Northern Beaches Hospital SSI Application SSI 13_5982

Submissions Report/Preferred Infrastructure Report

February 2014

Monday July 8, 2013

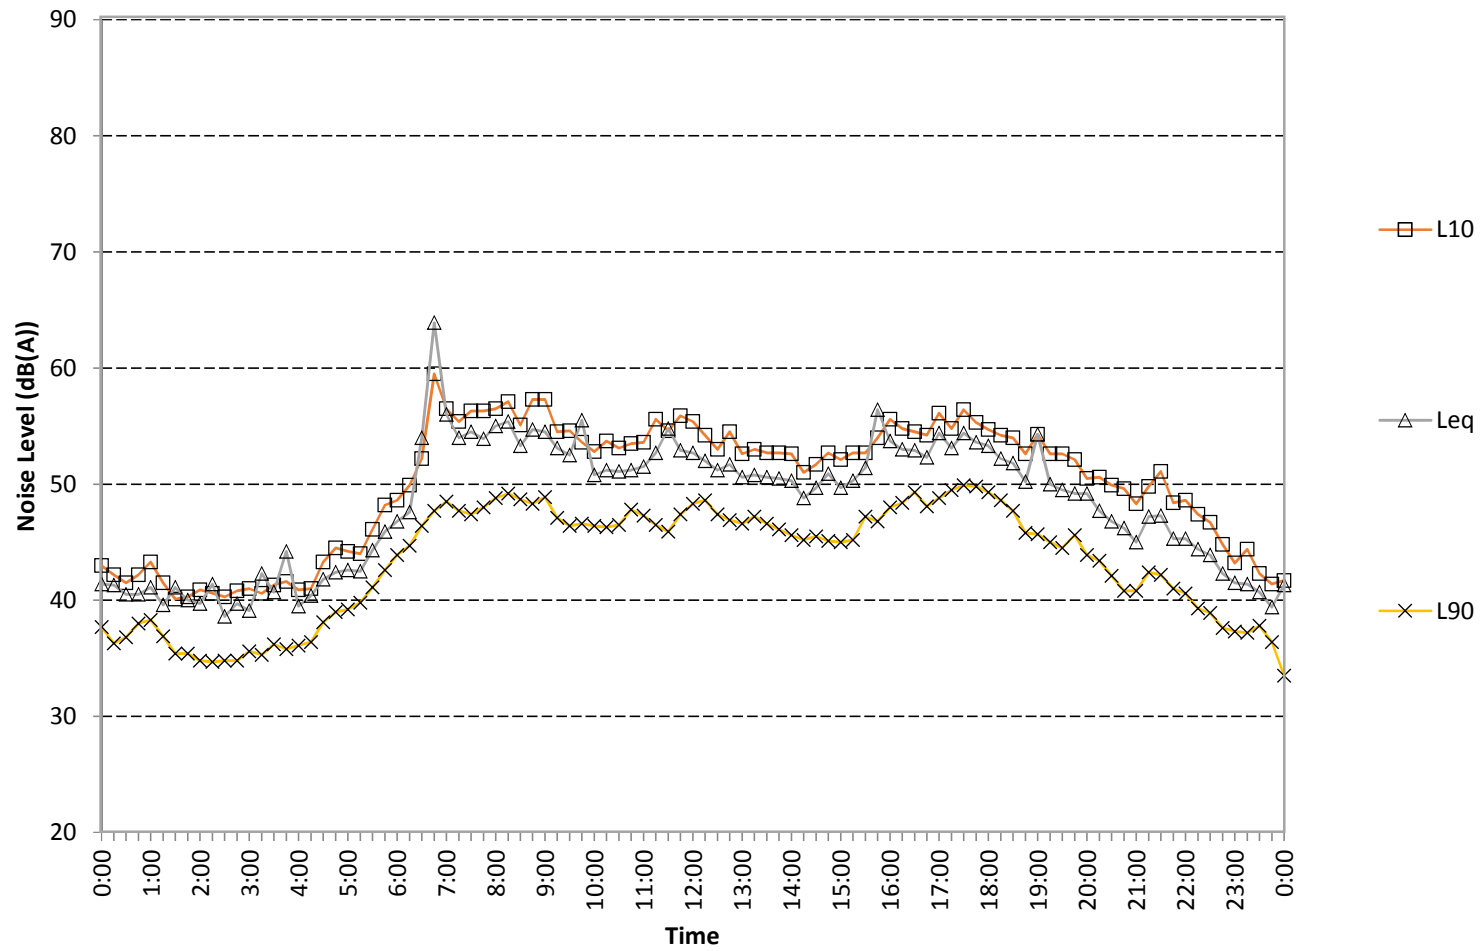
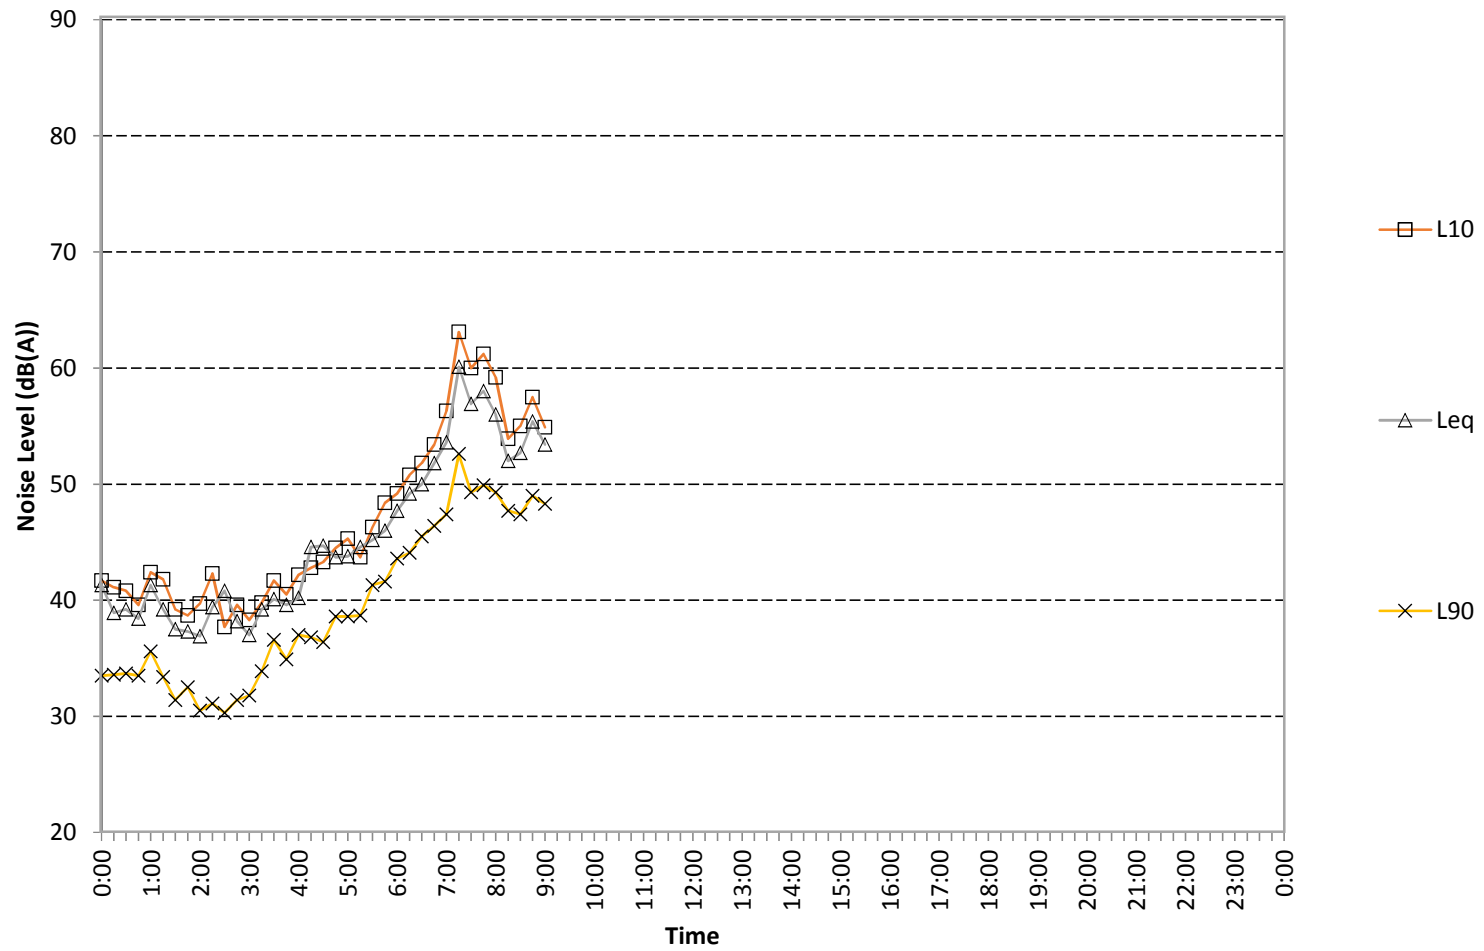
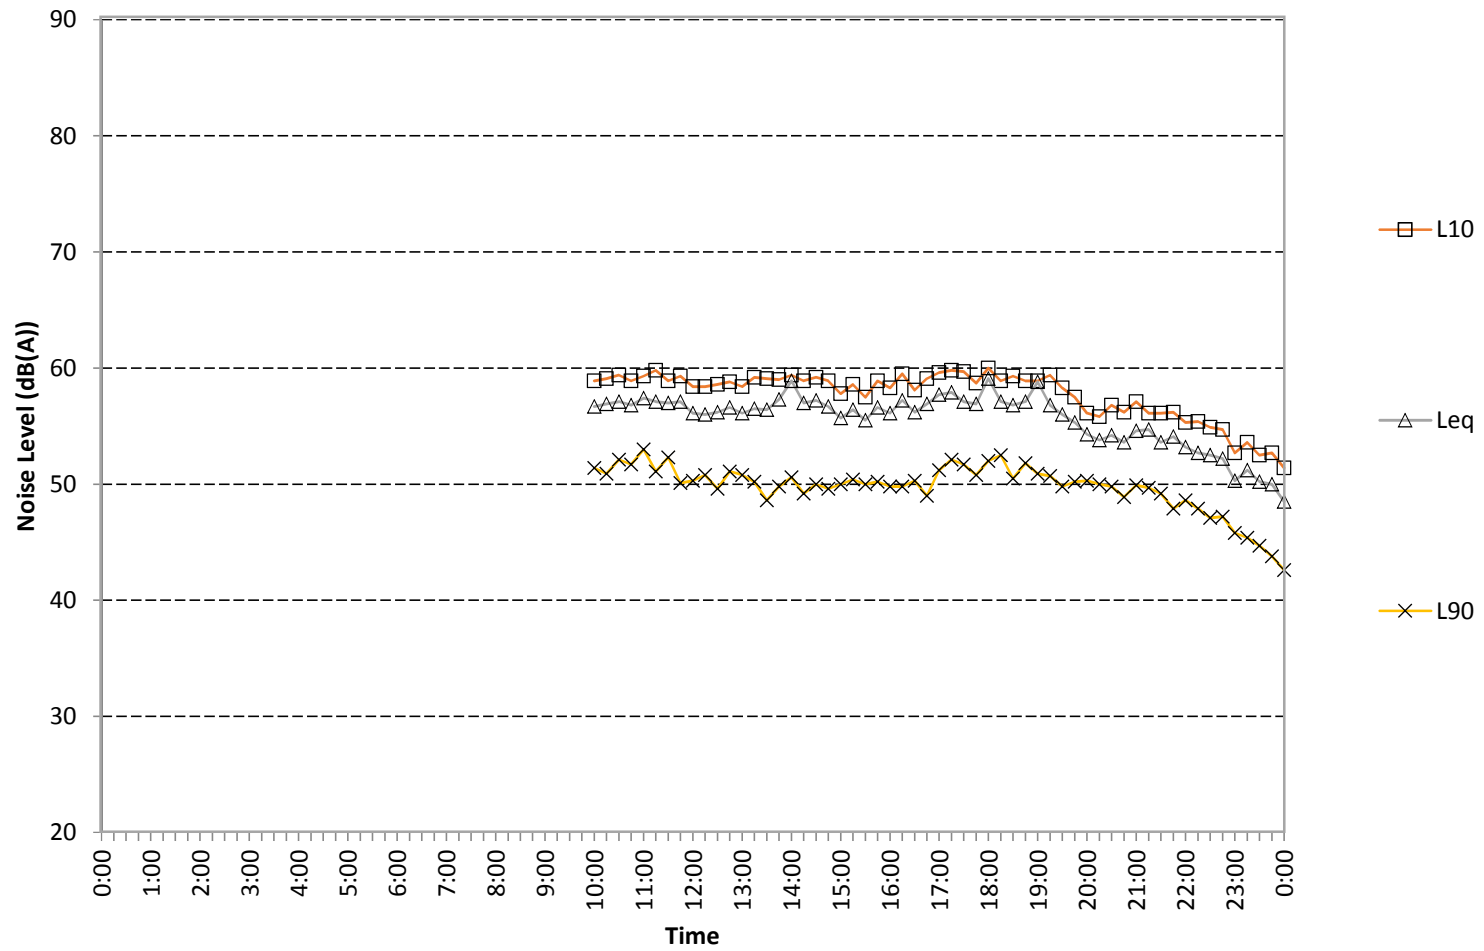
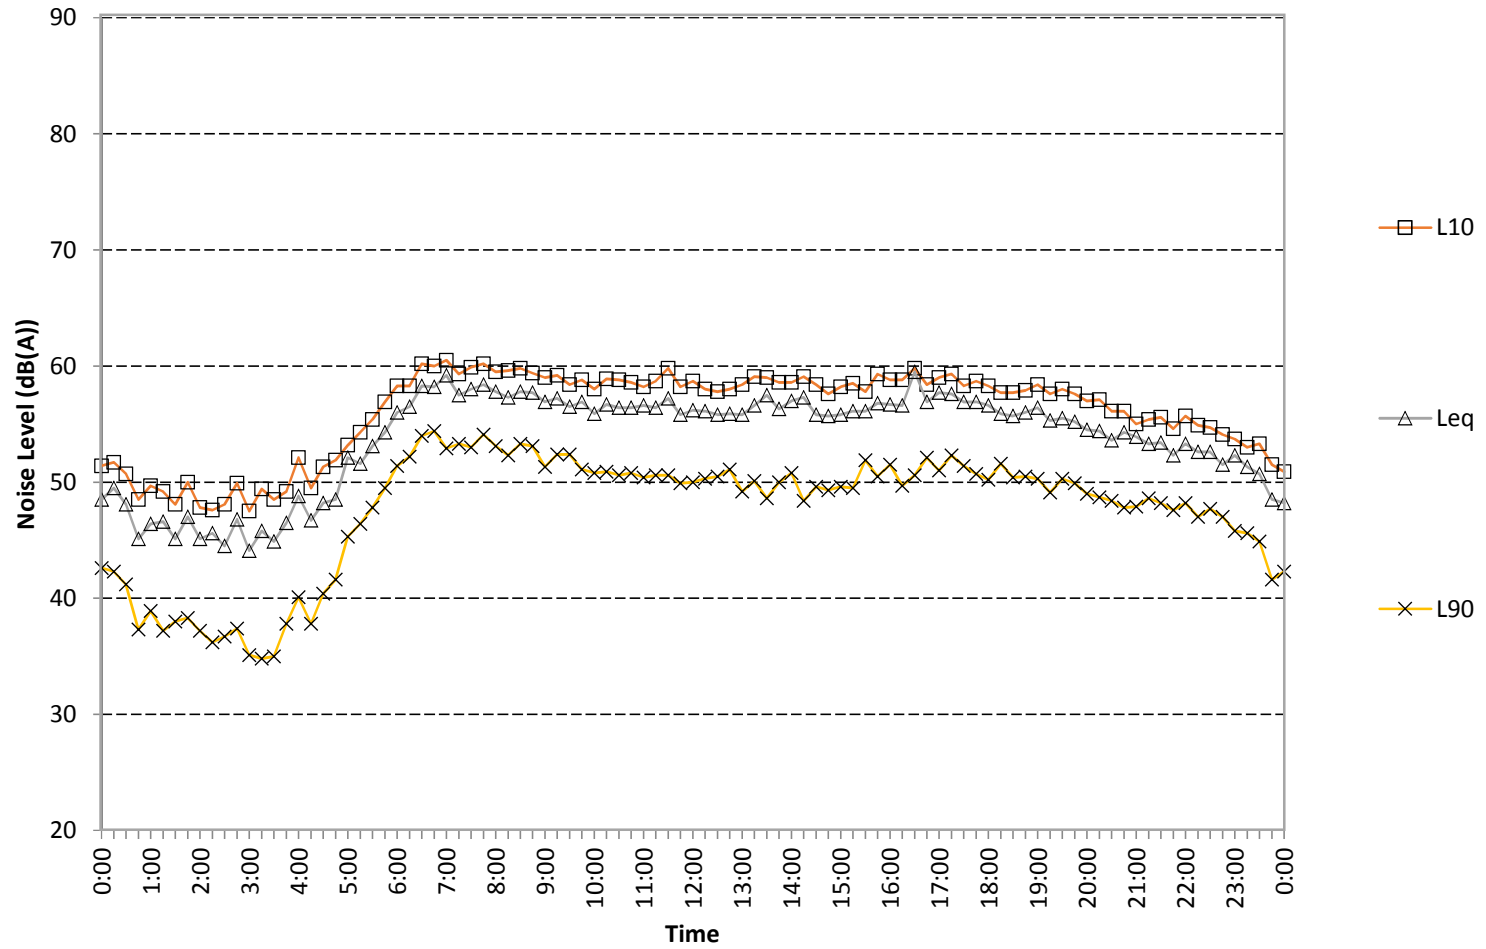
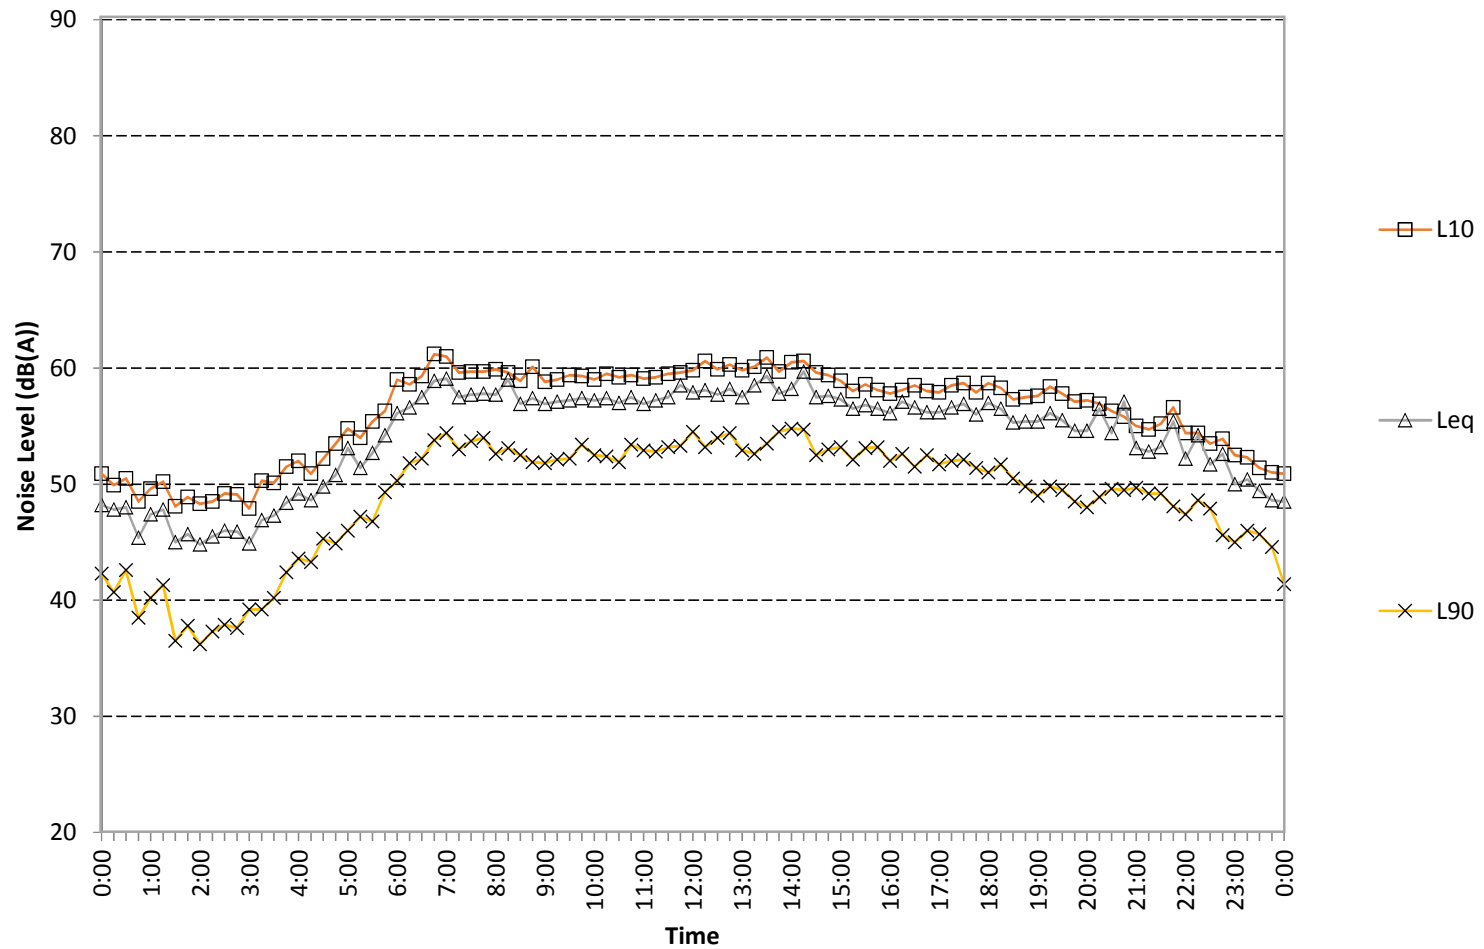
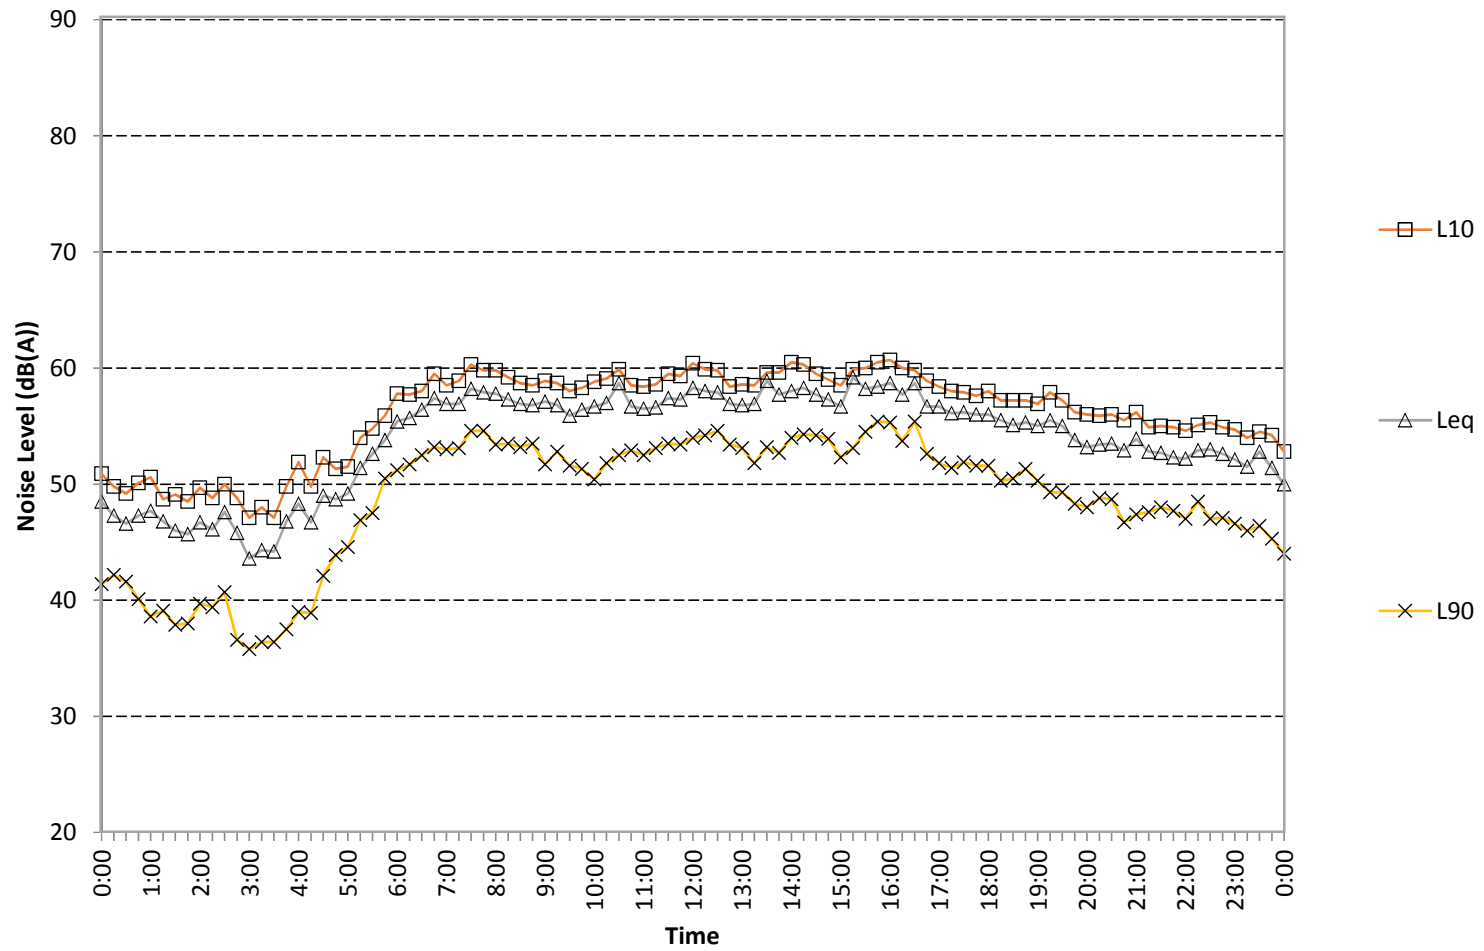
25. Background noise levels in Table 1 in Appendix K.	<p>There is a transposition error in the table. The noise levels for logger A should be against logger B and vice versa. There is a similar transposition error in Table 2 with respect to the noise-affected levels for residences on Frenchs Forest Road West and Warringah Road.</p> <p>These transposition errors have not affected the analysis, nor the conclusions drawn.</p> <p>Amended versions of these two tables are provided in Section 3.3 of this report. Background noise levels and noise criteria for periods outside of the recommended standard construction hours have also been included for completeness.</p>
